From: Thomas Callaway
Sent: 17 June 2015 15:49
To: Planning.Responses
Subject: RE: Planning Consultation on: M/52/15/HH

APPLICATION M/52/15/HH

Site Address: 3 Manor Way Elmer PO22 6LA

Description of Works: Single storey front extension.

proposed roof plan

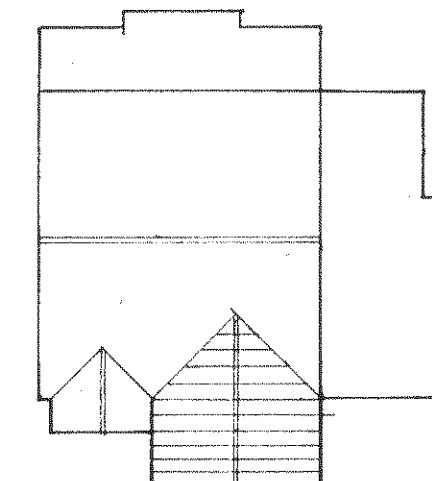
New roof areas should be drained. Infiltration should be investigated.

Please apply standard conditions ENGD2A.

Infiltration rates for soakage structures are to be based on percolation tests undertaken in the winter period and at the location and depth of the proposed structures. The percolation tests must be carried out in accordance with BRE 365, CIRIA R156 or a similar approved method and cater for the 1 in 10 year storm between the invert of the entry pipe to the soakaway, and the base of the structure. It must also have provision to ensure that there is capacity in the system to contain below ground level the 1 in 100 year event plus 30% on stored volumes, as an allowance for climate change. Adequate freeboard must be provided between the base of the soakaway structure and the highest recorded annual groundwater level identified in that location.

Any SuDS or soakaway design must include adequate groundwater monitoring data to determine the highest winter groundwater table in support of the design. The applicant is advised to discuss the extent of groundwater monitoring with the Council's Engineers. Supplementary guidance notes are also enclosed for information.
